## Department of Primary Industries

### **Kurri Kurri Battery Recycling Facility (SSD 7520) Comment on the Environmental Impact Statement**

DPI has reviewed the application and Environmental Impact Statement (EIS) and provides the following recommendations:

Figure 6 – Surface Water Management Plan

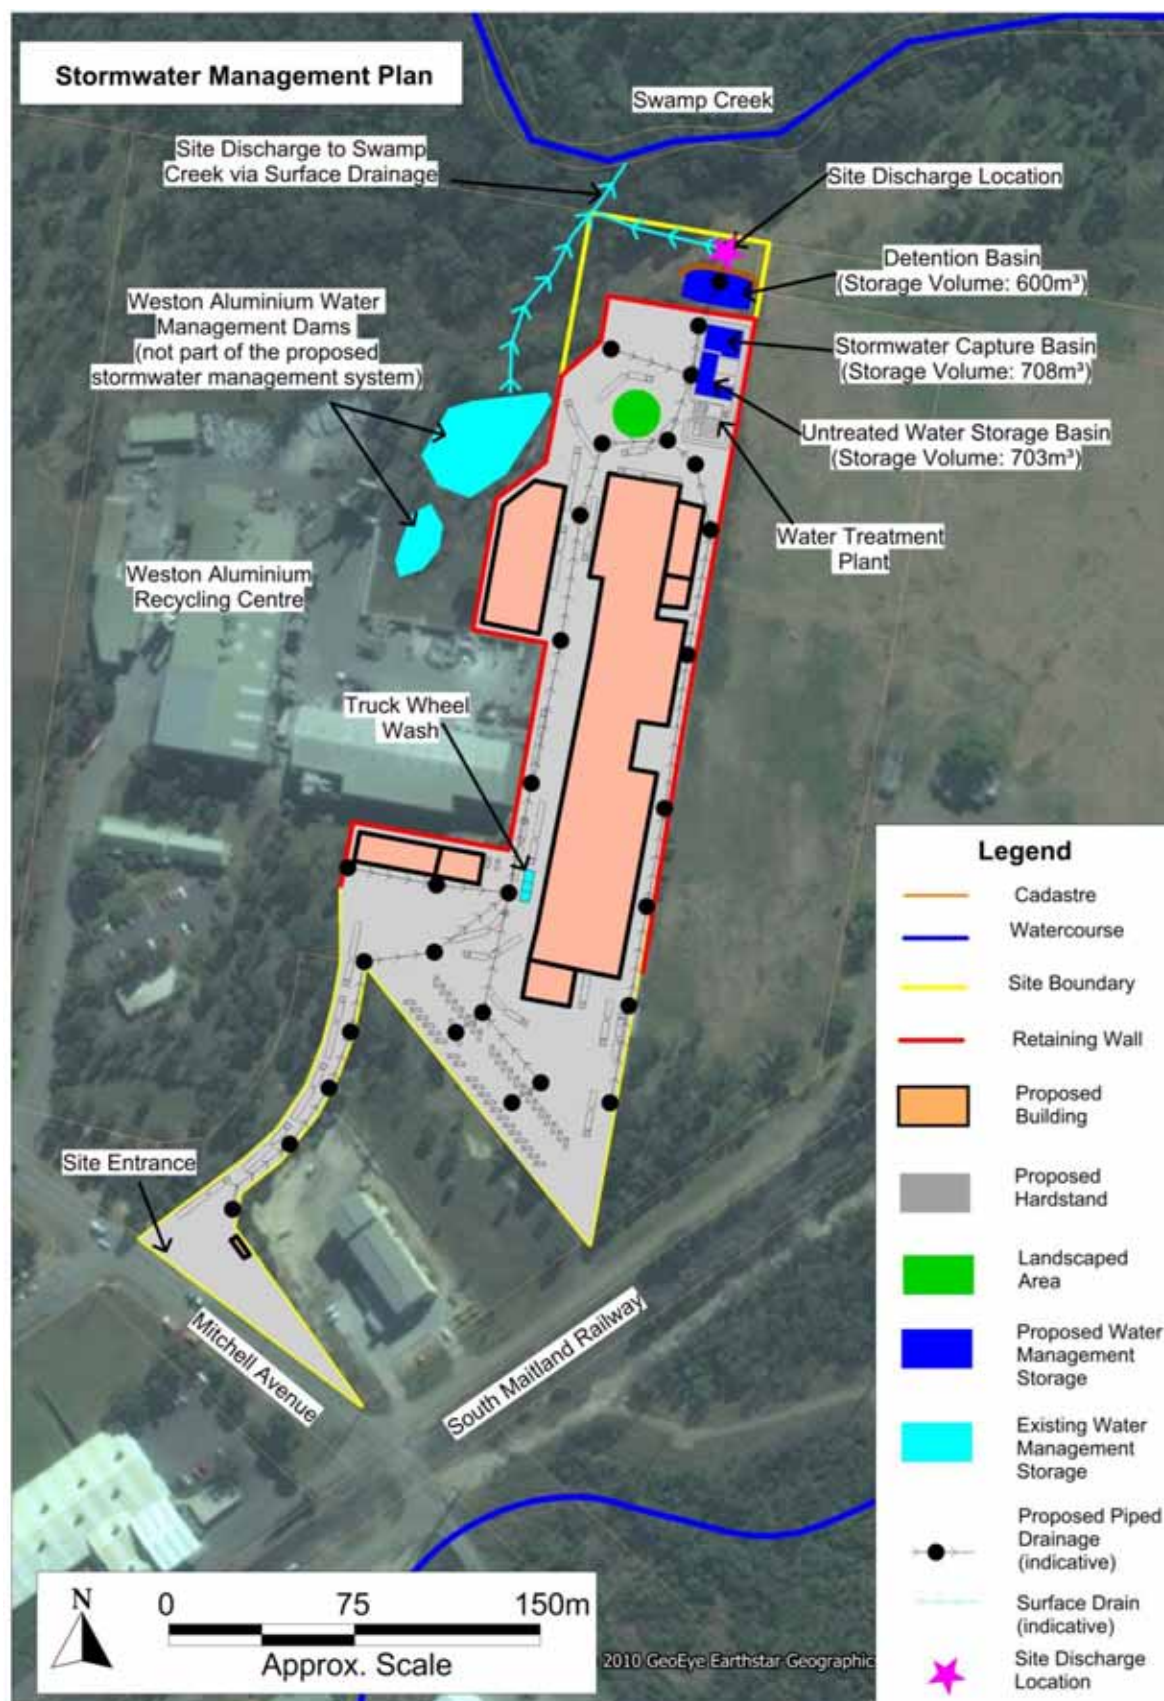
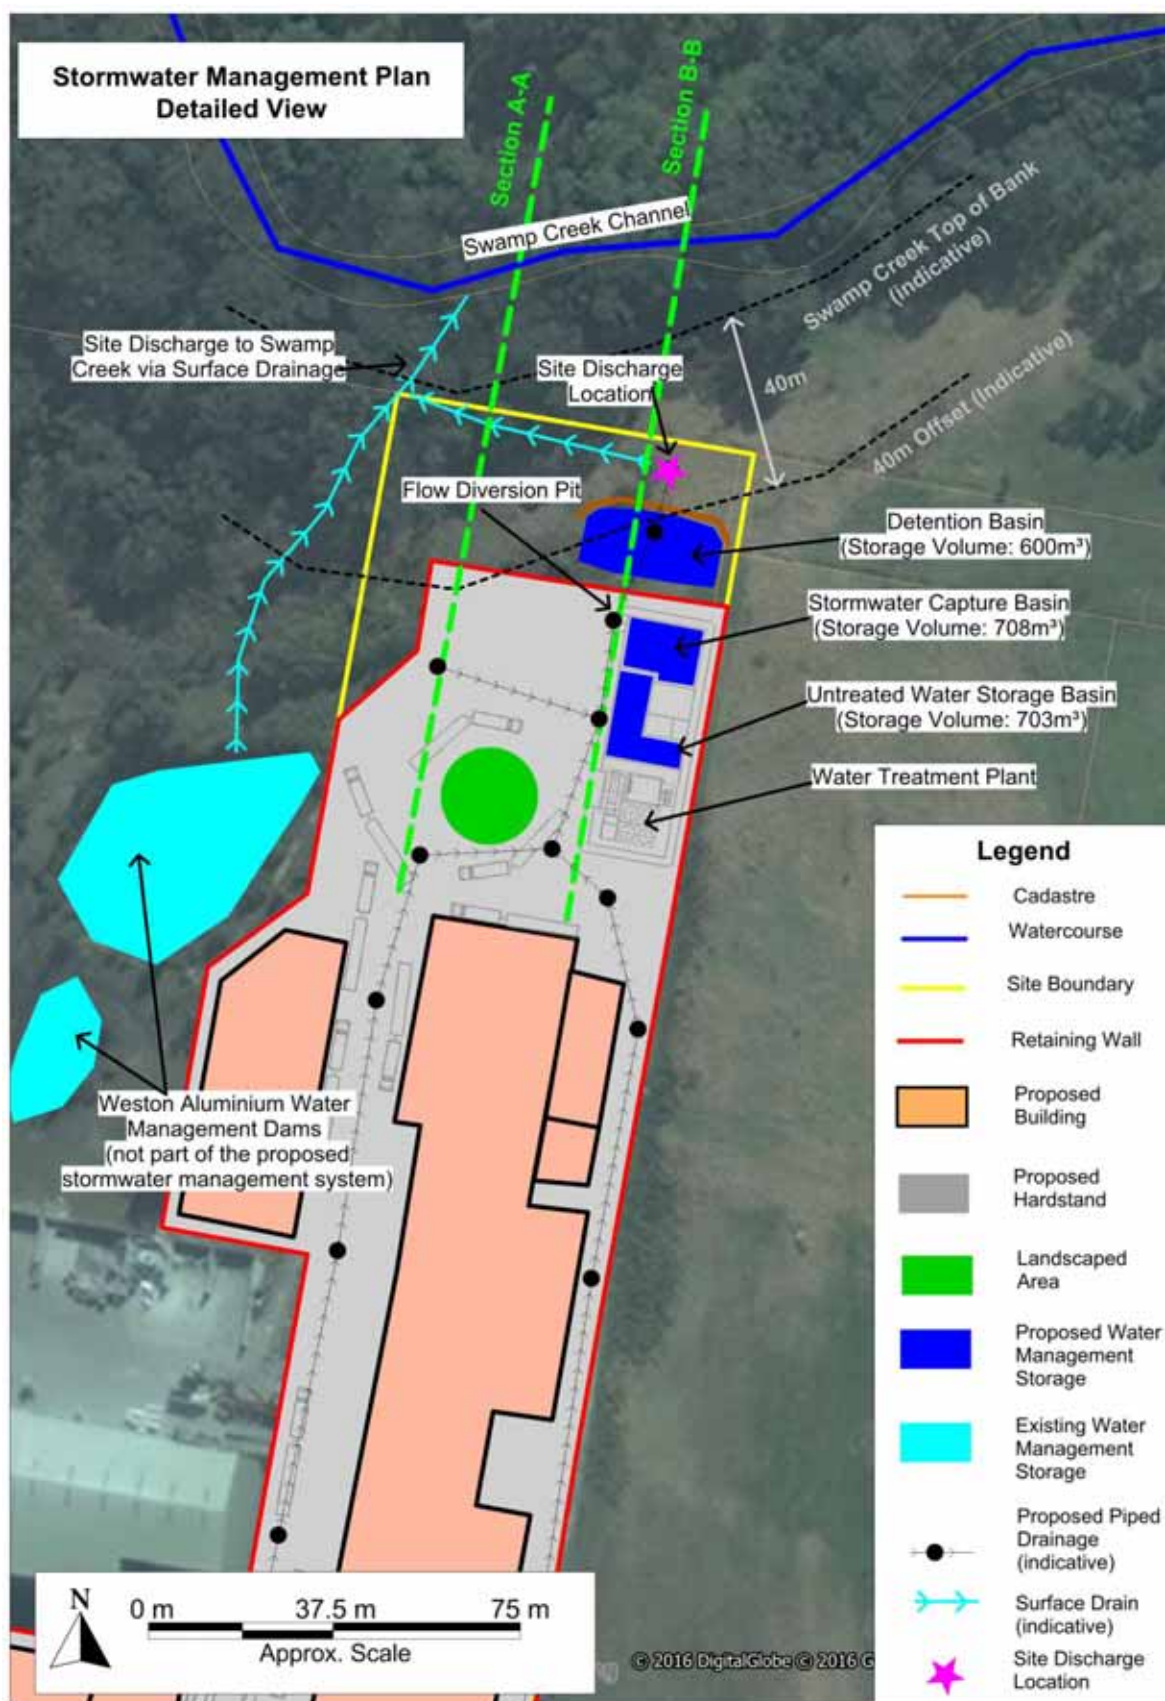
- The proponent should install an appropriately designed liner to mitigate impacts to groundwater from the:
  - Flow diversion pit.
  - Stormwater capture basin.

- The proponent should ensure that the stormwater capture basin has sufficient capacity, at all times, to contain the first rinse volume of runoff water for the site, immediately following a dry period.

- The stormwater capture basin should be continuously monitored by a water level logger. Trigger Action Response Plans should be developed to ensure sufficient capacity to contain the first rinse volume of runoff water for the site.

Figure 17 – Peak Flood Depth and Level – 1% AEP Event

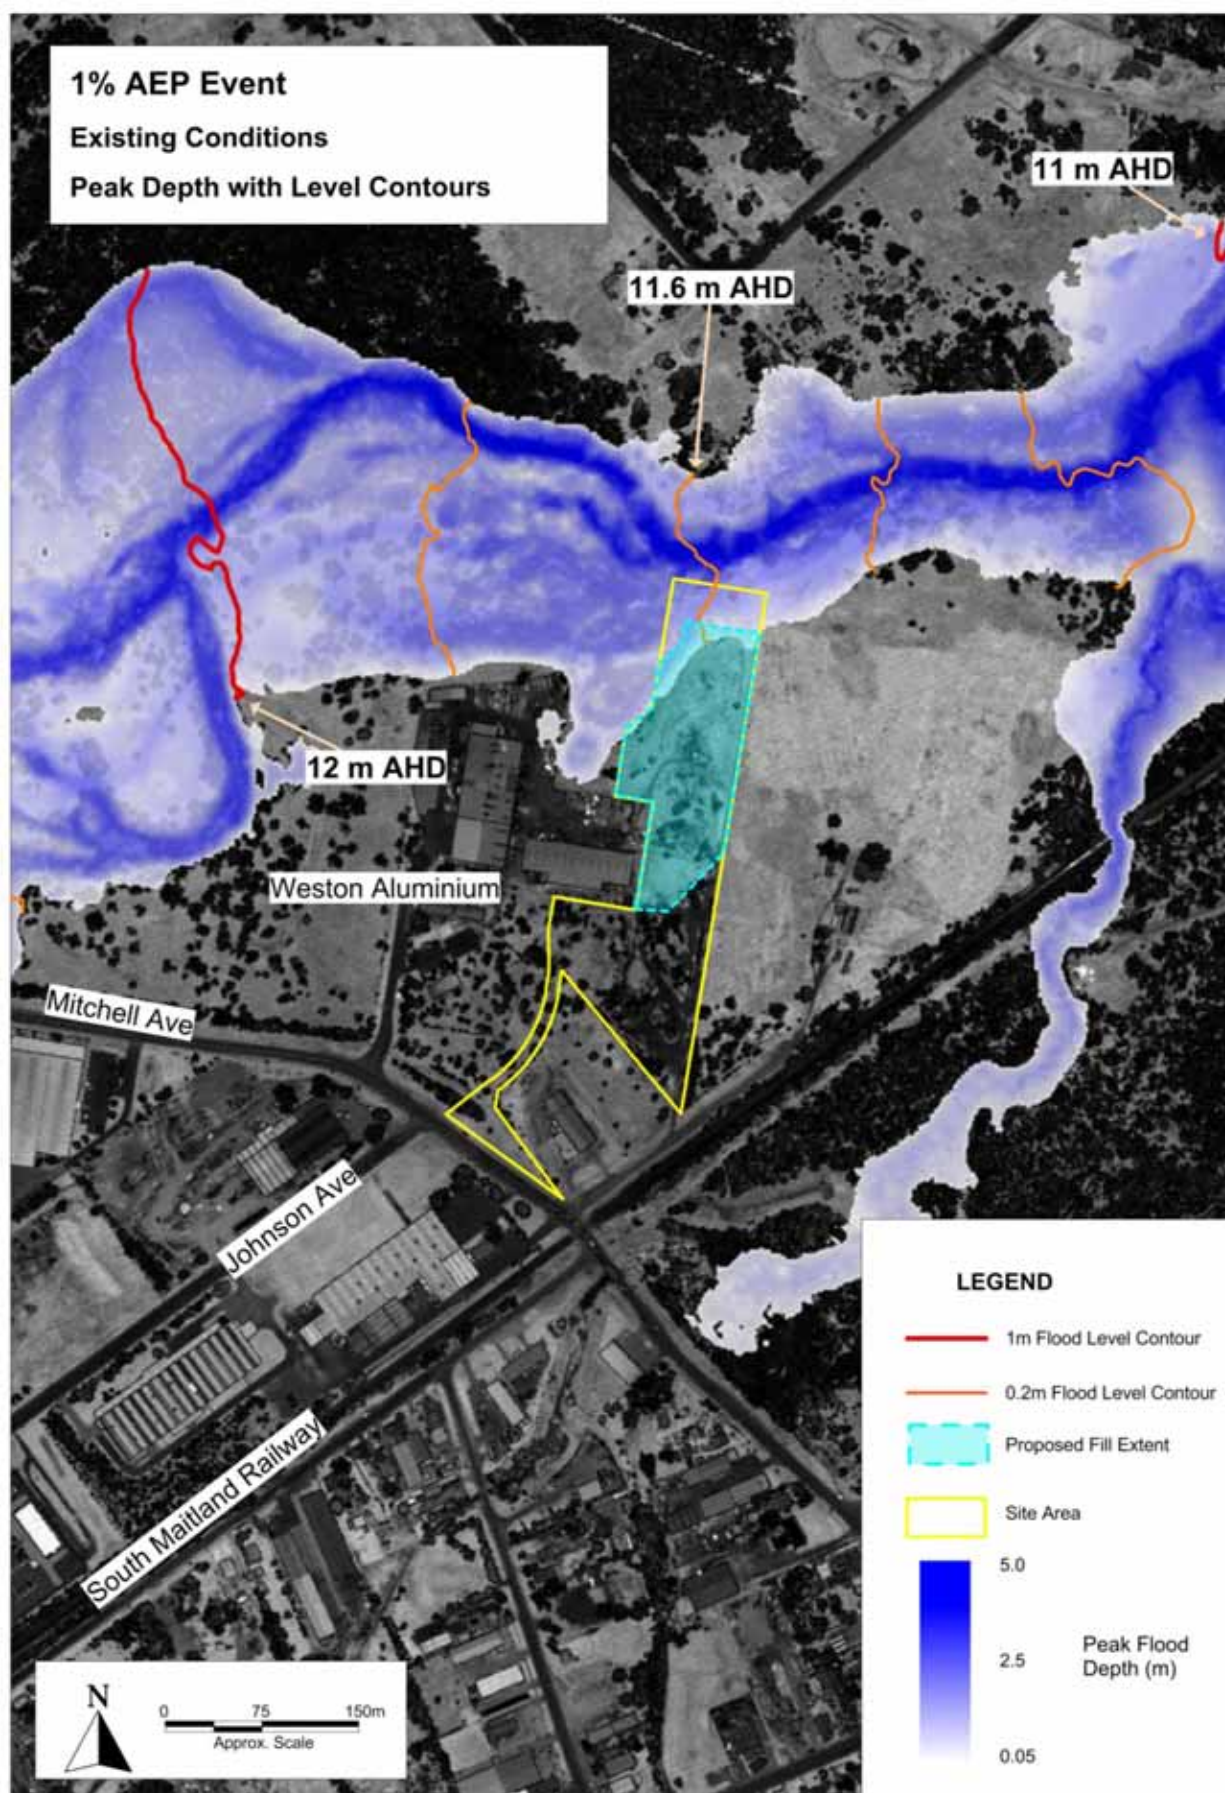
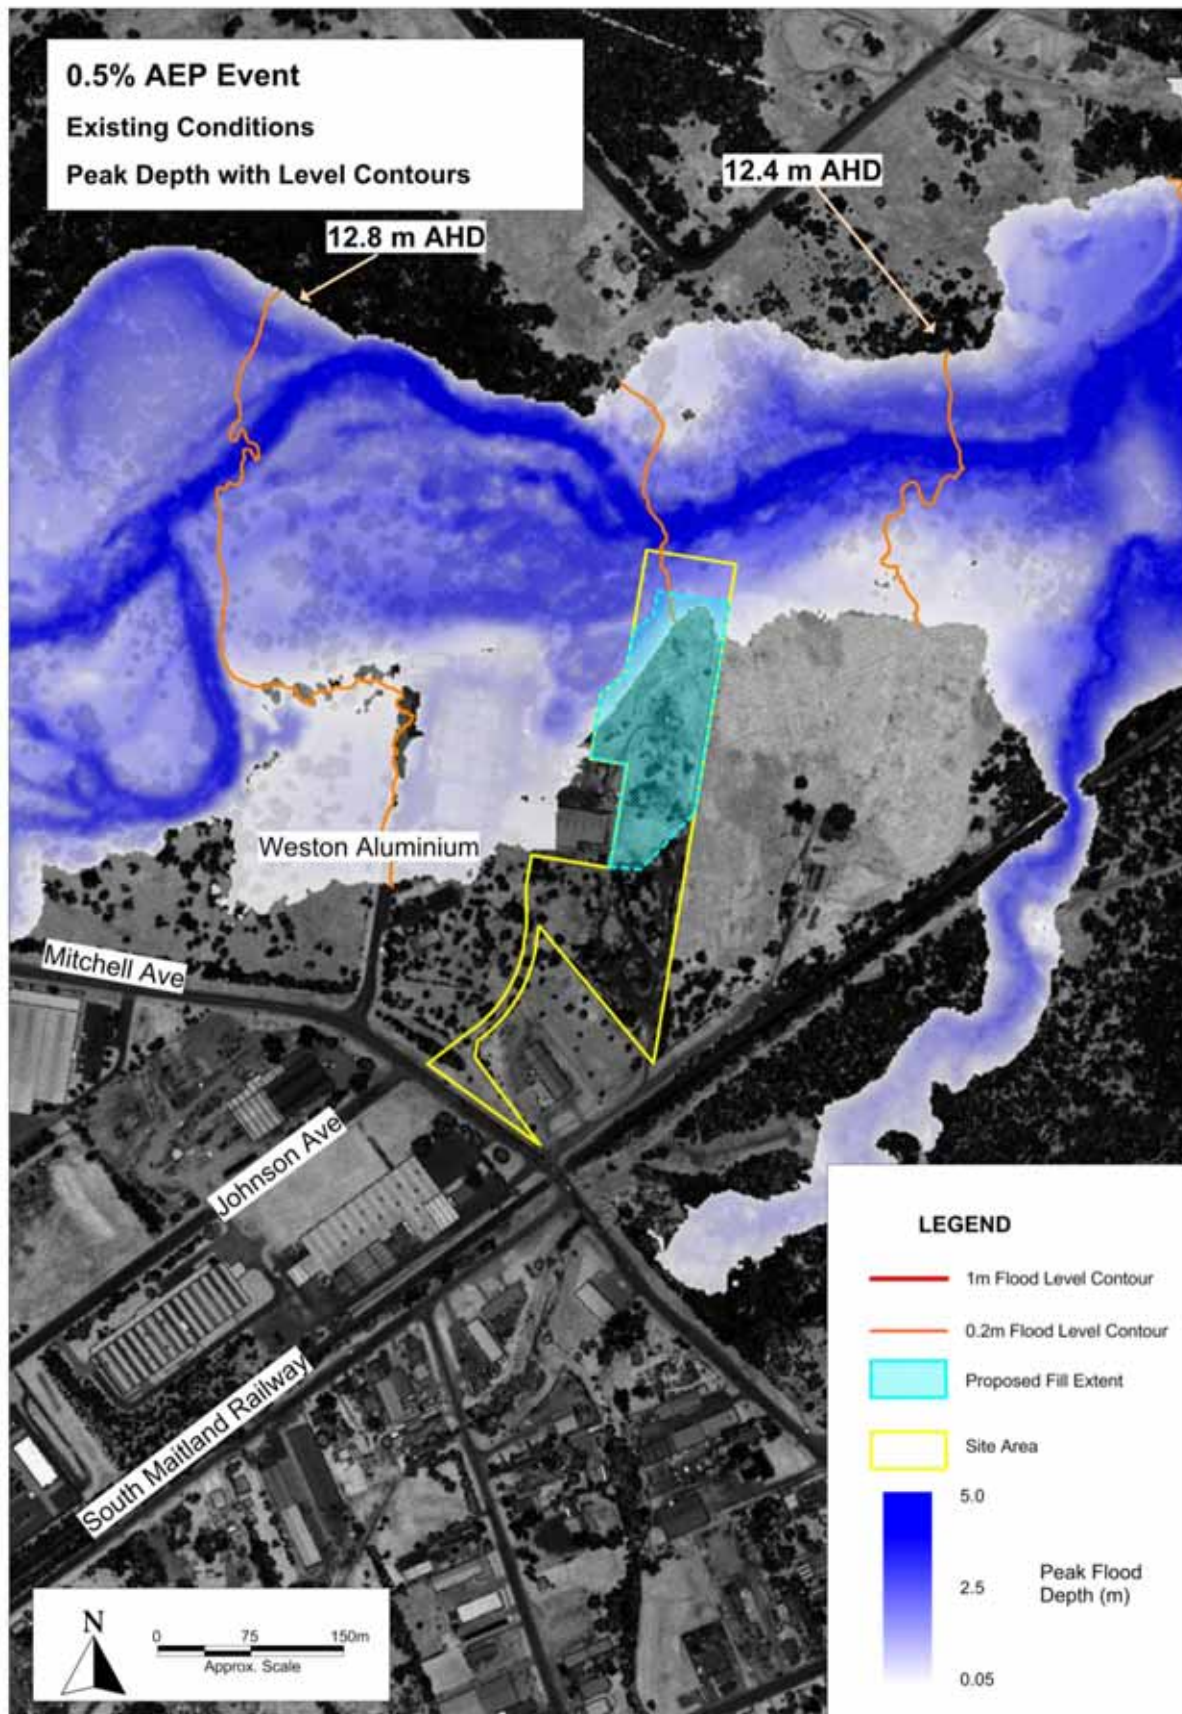
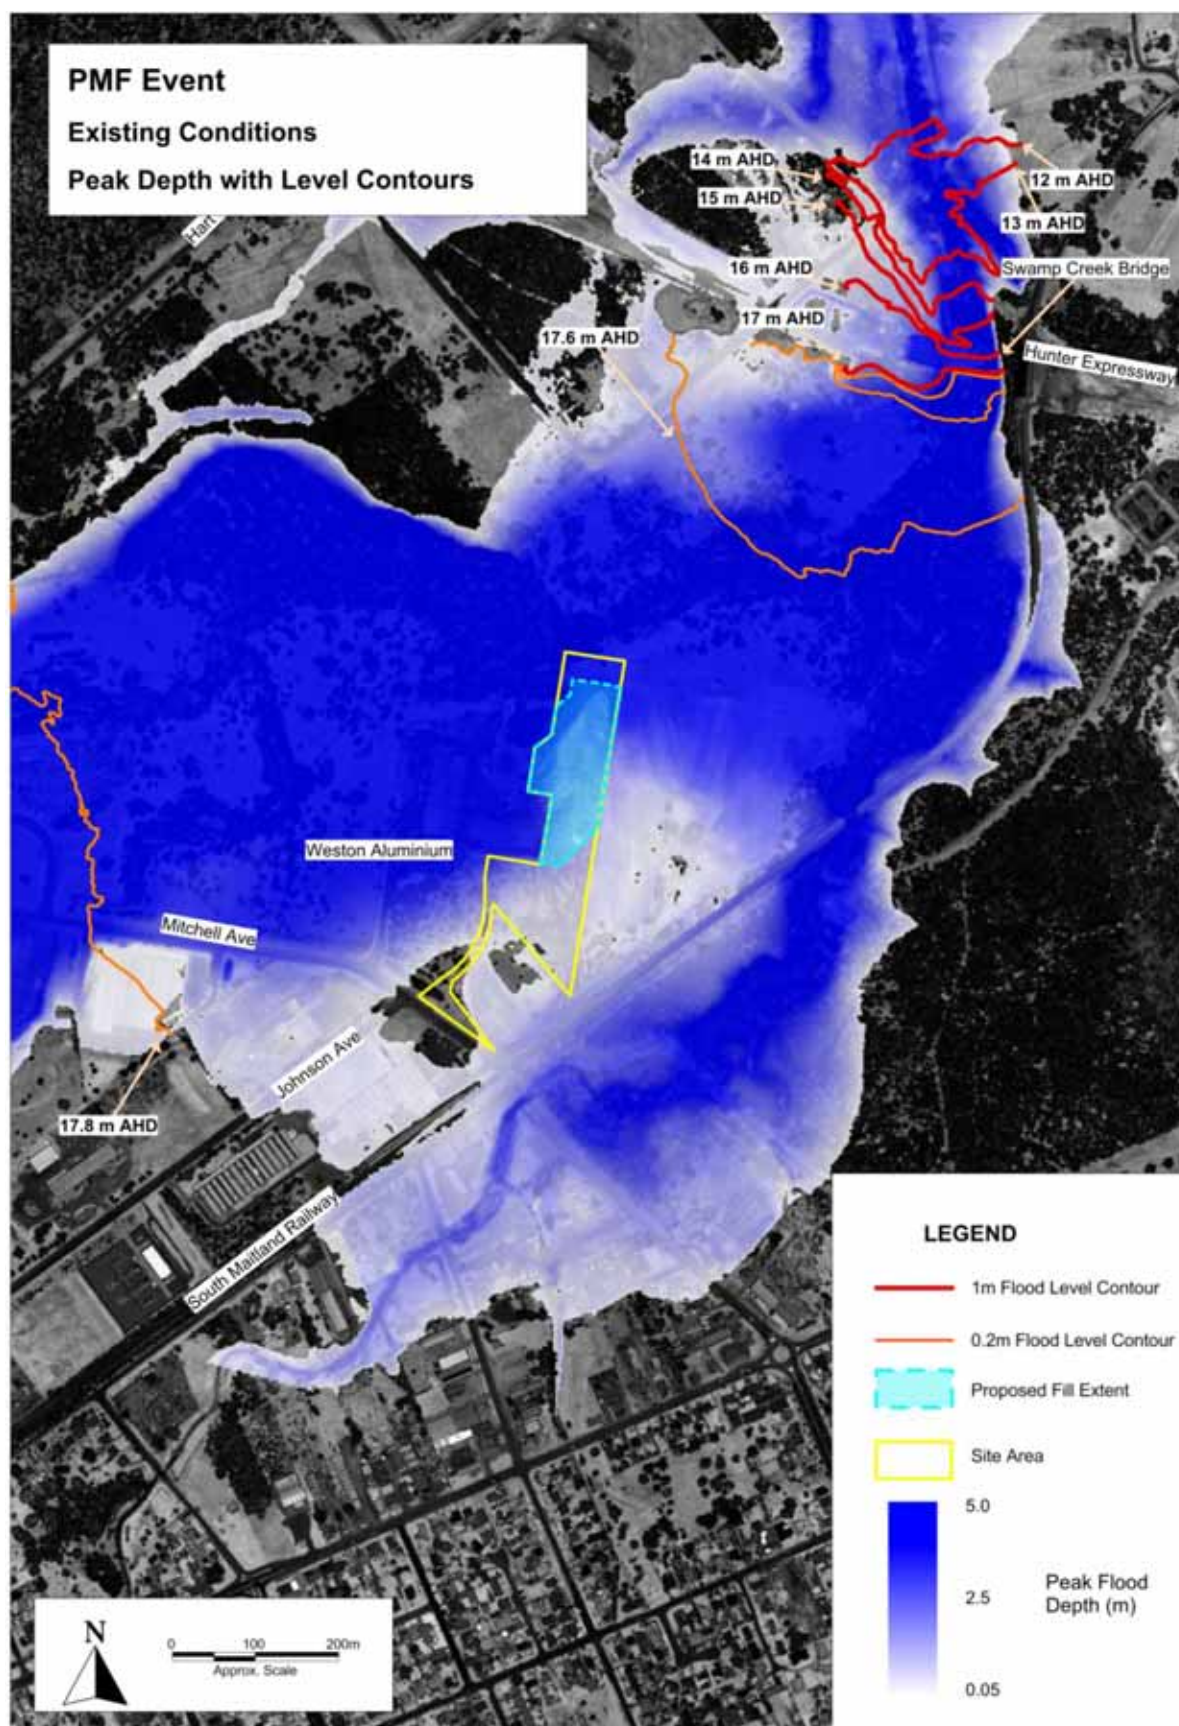
- The proponent should re-issue maps to a suitable scale, clearly showing the flooding depths and extents, and also a legible map of the surface topography of the site.
